**From:** [Simon Wood](#)  
**To:** [Sarah Madyausiku](#)  
**Cc:** [Planning](#)  
**Subject:** Further comments: 6/2018/3254/COND: Stanborough School Lemsford Lane Welwyn Garden City AL8 6YR [HN1456]  
**Date:** 31 January 2019 15:53:31  
**Attachments:** [HN1456\\_ProjectDesign\[RevA\].pdf](#)

Proposed layout, Trench 6

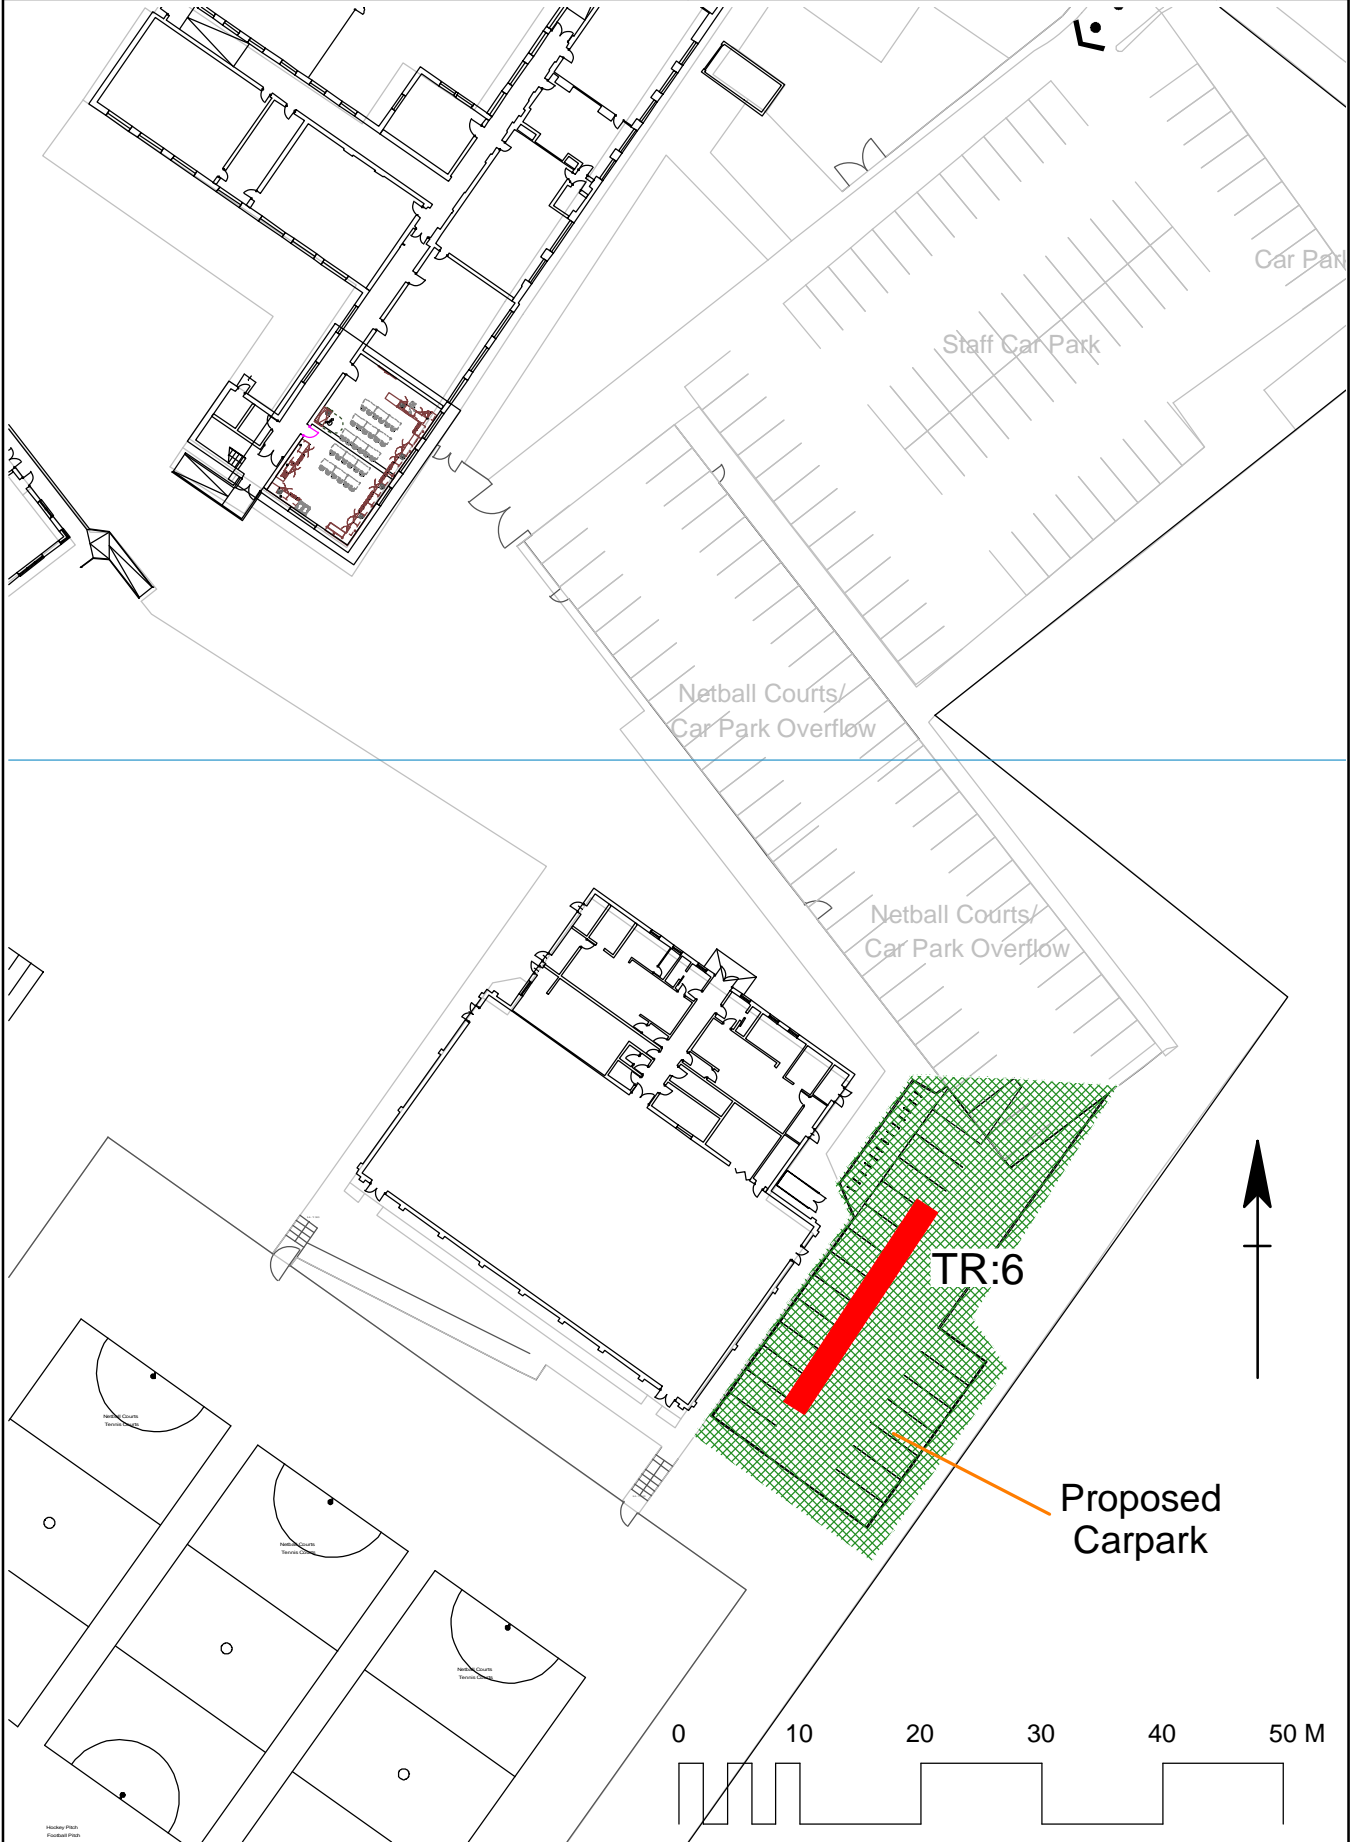
I can confirm that I have received an updated Written Scheme of Investigation directly from the applicant's agent that meets my comments of 24 January 2019.

We have updated the document with the addition of a further trench in the middle of the site to address your concerns. We have copied in the planning department at WHBC and our client's architect, who can resubmit the document formally to WHBC, if required.
